Address: 1, Sunny View, Batley, WF17 8FP

Application number: 2026/90310	
What is the application for?:	Erection of 37 dwellings with associated access, parking, landscaping and creati
Address of the site or building:	land off, Sunny View, White Lee, Batley, WF17 8FP
Postcode:

Proposed Site Layout

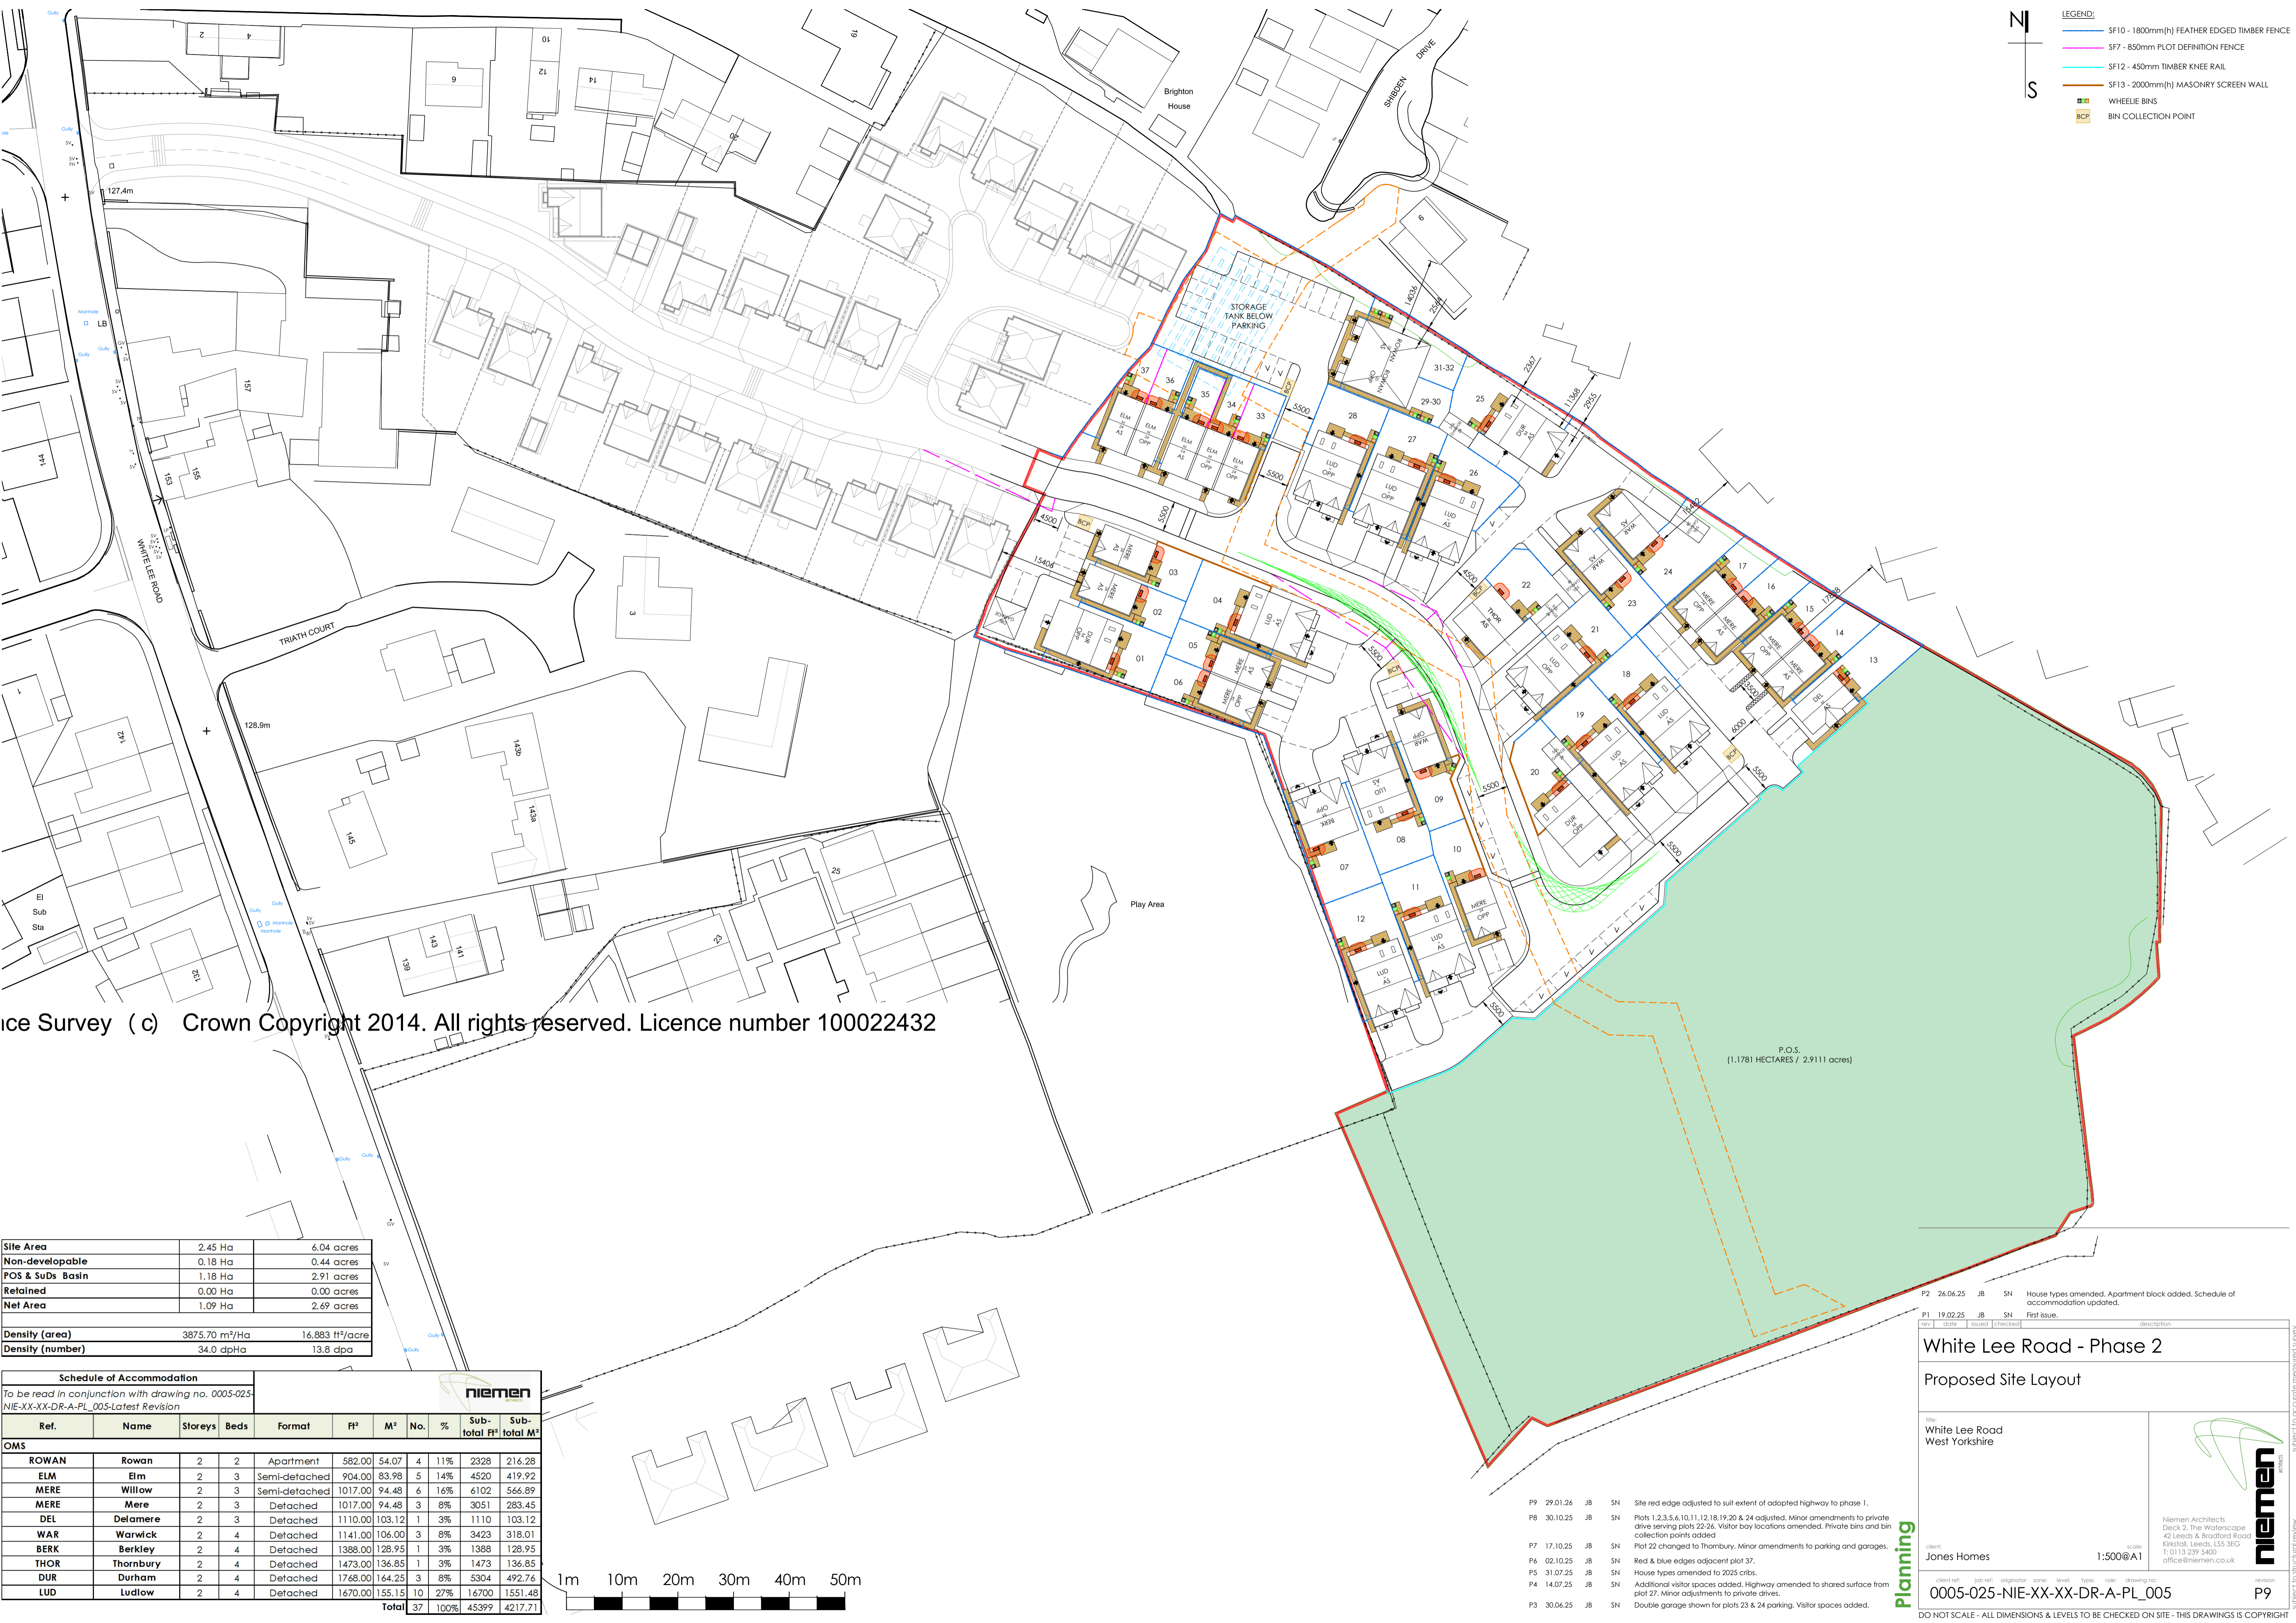
The land is not redundant, and the proposed internal open space does not replace its function, as it would be fragmented and enclosed by development. Approval would also weaken protection against further incremental loss.

The scheme relies on engineered drainage, including a storage tank beneath parking, raising concerns regarding maintenance, failure risk and long-term management. Policy LP28 requires secure lifetime arrangements, which have not been demonstrated.

Additional delivery and servicing activity would introduce manoeuvring within a constrained residential environment, increasing pedestrian–vehicle conflict, particularly for children.
